January 20, 2021

### ***Re: Windermere Preliminary Plan (SP-19-003)***

Please accept this response letter to comments received December 9, 2020

PRELIMINARY  
SITE PLAN

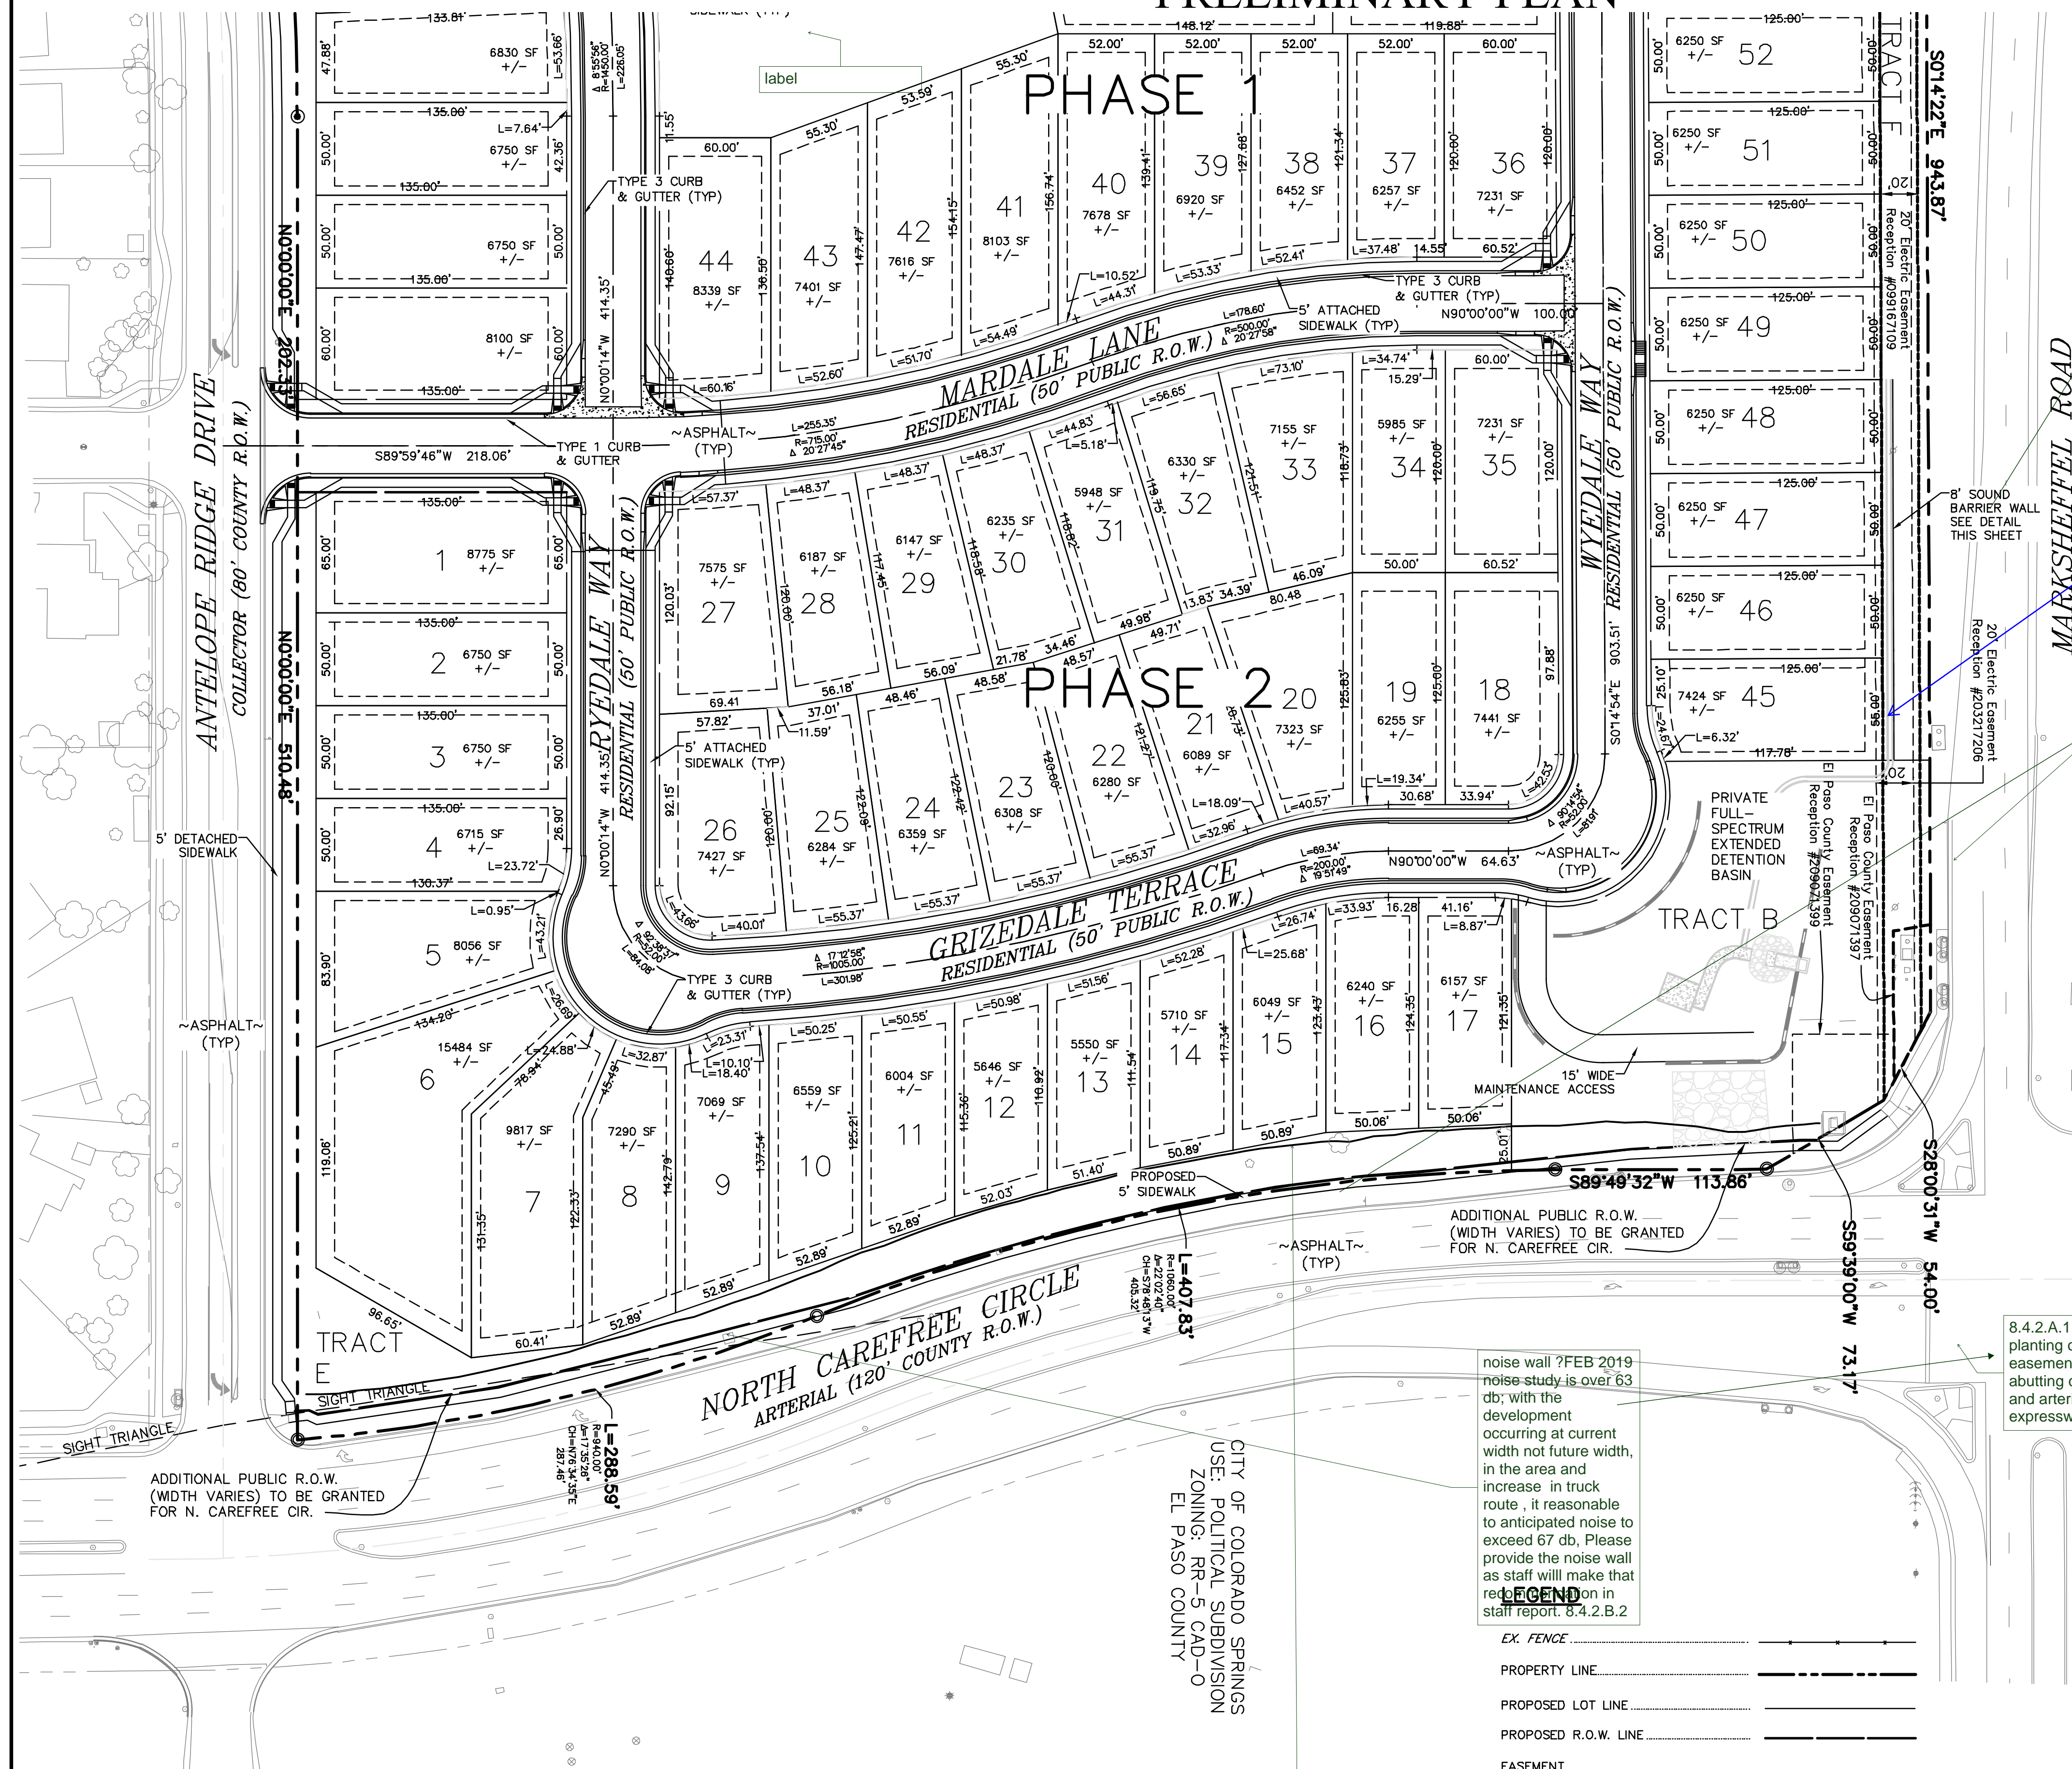
2. Resolved.
3. See Preliminary Plan redlines for additional comments. ***Partially resolved; see remaining redlines. Marksheffel Road right-of-way dedication remains an issue. Marksheffel right-of-way dedication updated, ref. prelim plan.***

3. *Roadway landscape requirements are required (Carefree & Marksheffel). Please see Section 6.2.2, Table 6-1; Buffer requirements apply as discussed in Section 6.2.2.D.2. Please provide the landscape exhibit; this may include all buffer (screening as required in Section 8.4.2.A.1 also applies) or noise walls etc. Perhaps a tapered wall from 8-feet to 6-feet along Marksheffel is appropriate to meet screening requirements. If the noise*

study is determined to show db greater than 67 (currently greater than 66.4 db in places and greater than 65 db in majority) at plat the wall could be increased. **Landscape wall now shown along rear of lots that abut Marksheffel. Noise study will be updated at Final Plat and wall added along Carefree if deemed necessary at that time.**

6. Please note: The ECM identifies a noise wall requirement to meet Federal standards. The Federal standard is now 66db per February 2020-(Source CDOT). **Acknowledged. A 6-ft extension of the screen wall has been added to the plan along Marksheffel and Carefree. Noise study to be updated at final plat.**

**PRELIMINARY GRADING PLAN**

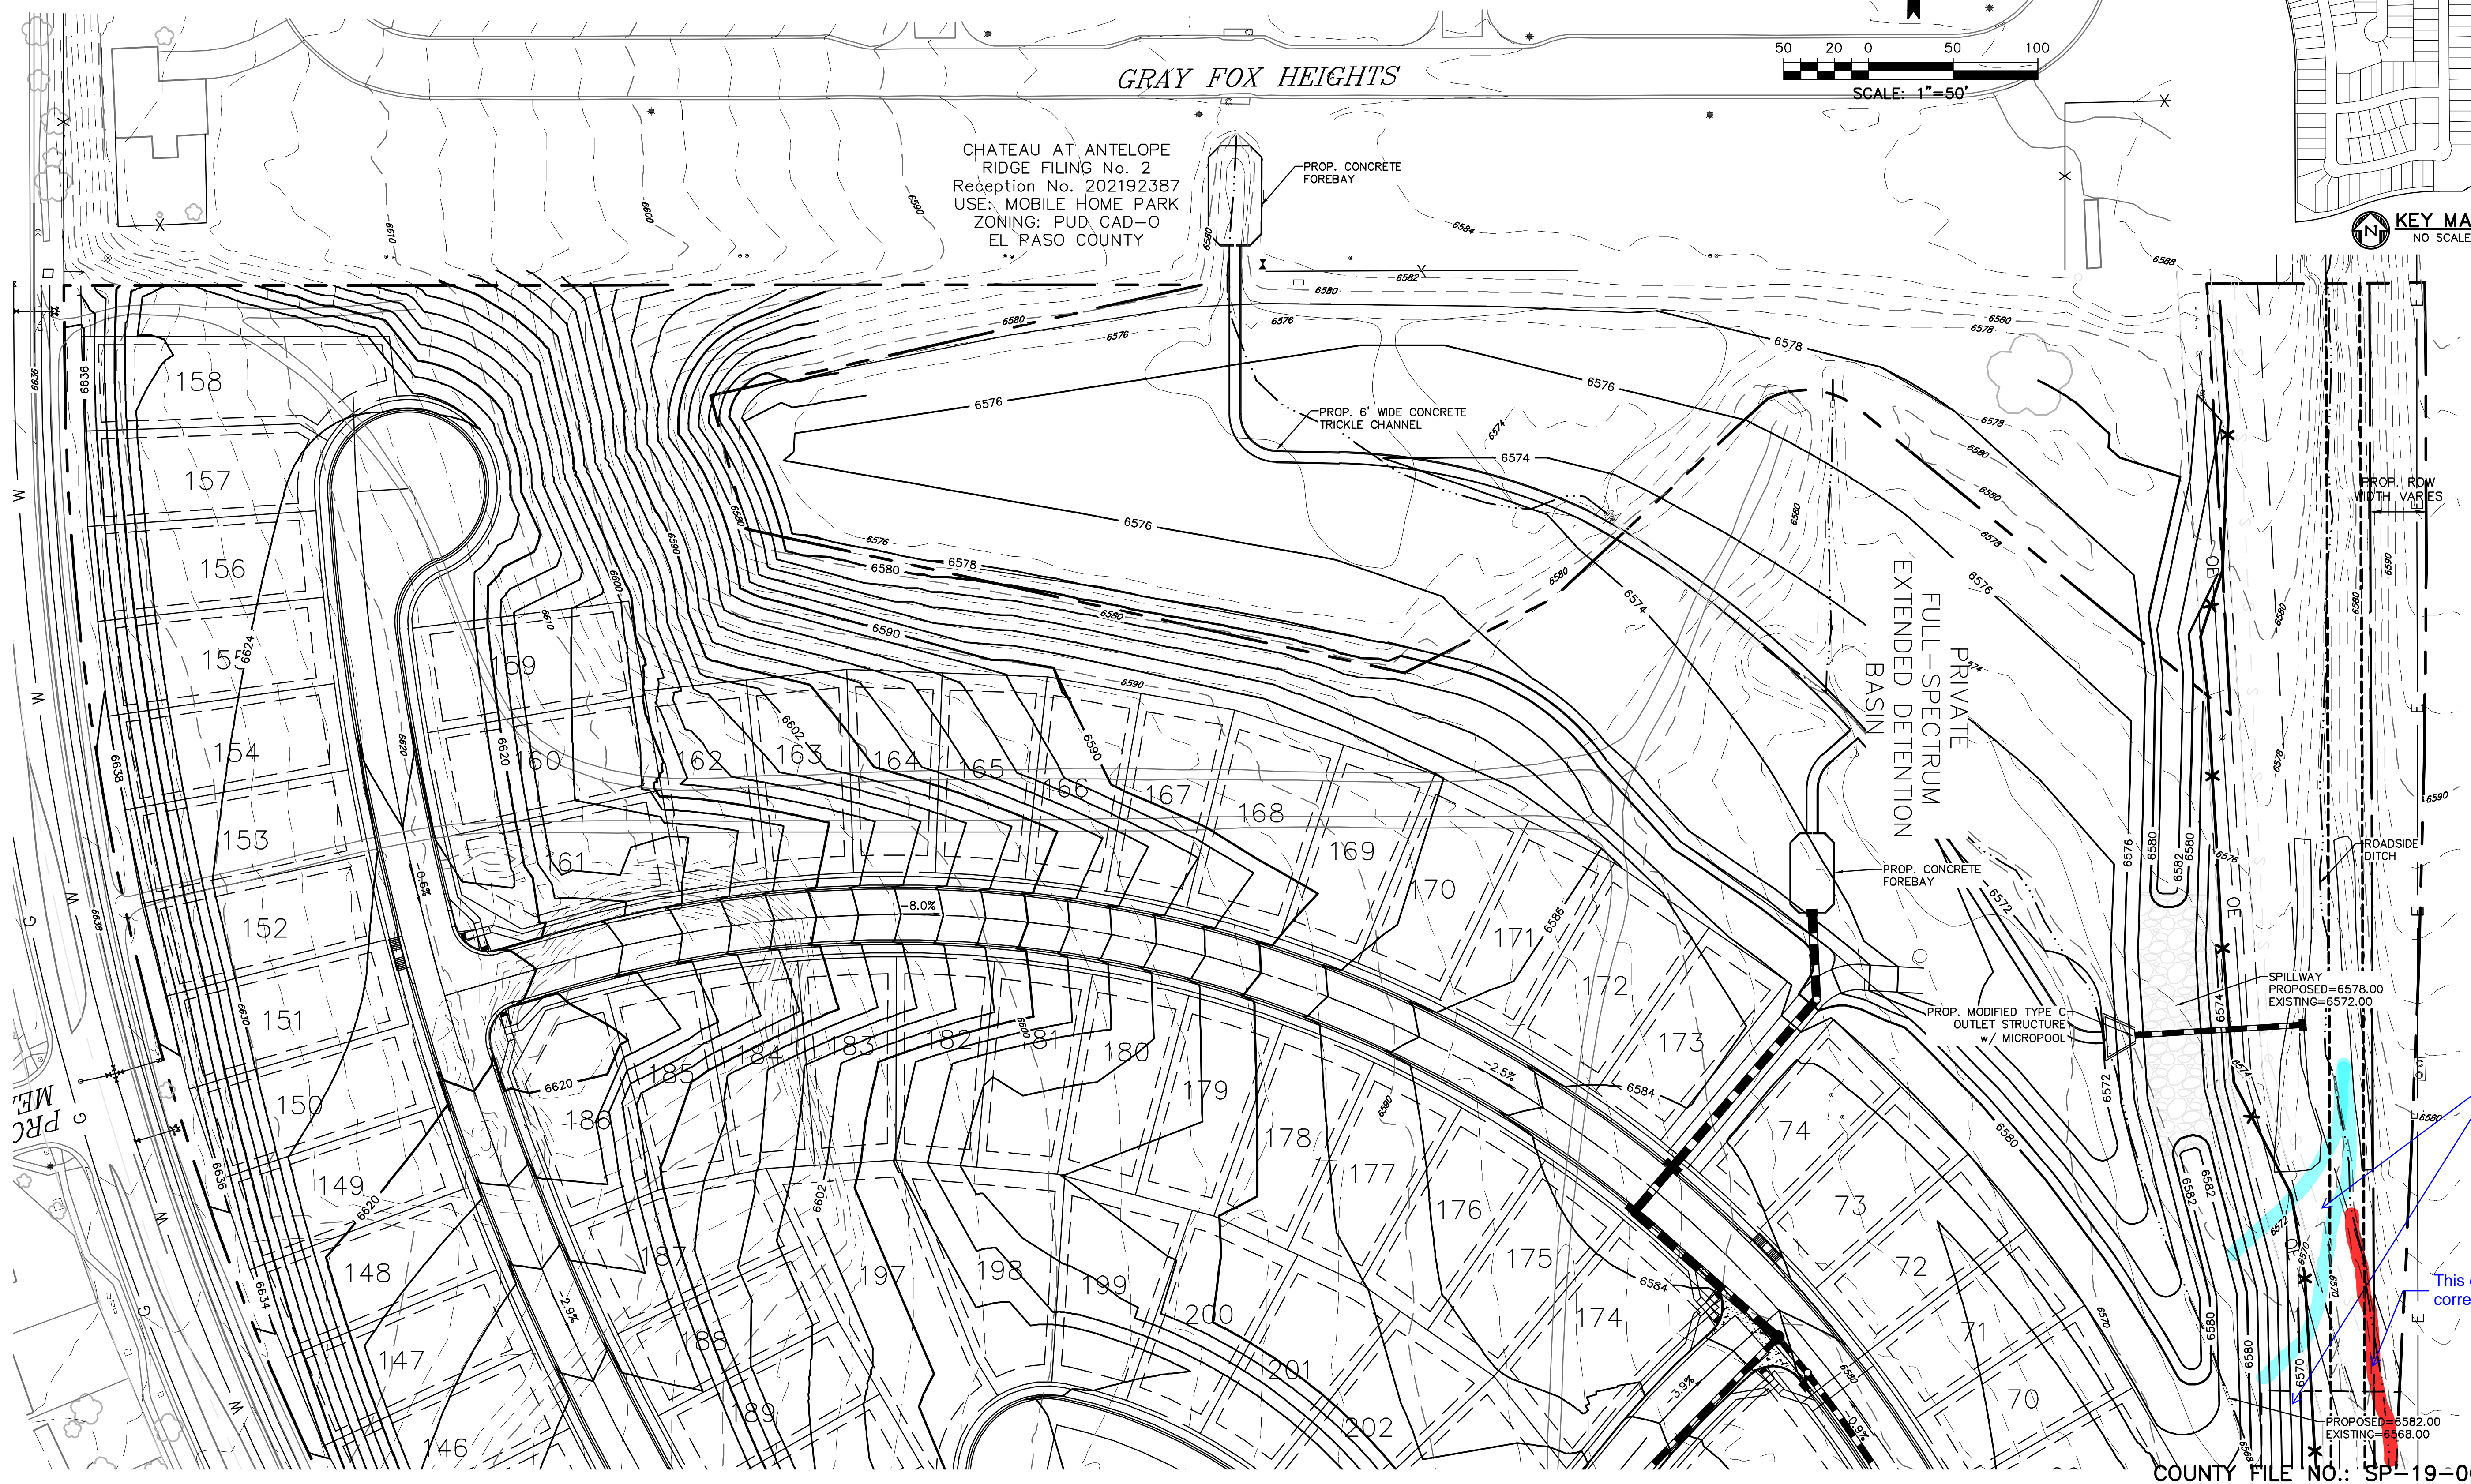
- b. Complete design details and grading and erosion control are required for the improvements at the southeast corner. It is unlikely that the existing area inlet will be allowed to be moved out of the existing County easement, or grading (fill) within the easement allowed. **Response is that a variance for grading in the easement will be applied for. This would require re-writing the easement and may not be possible. Grading has been adjusted so that there is no disturbance within the County easement.**

- c. See redlines regarding grading in the County easement near the northeast corner of the property (same issue as 3.b, above). **Unresolved; staff do not support a deviation for filling in this drainageway easement. As with comment 3.b. above – grading adjusted for no disturbance within the County easement.**
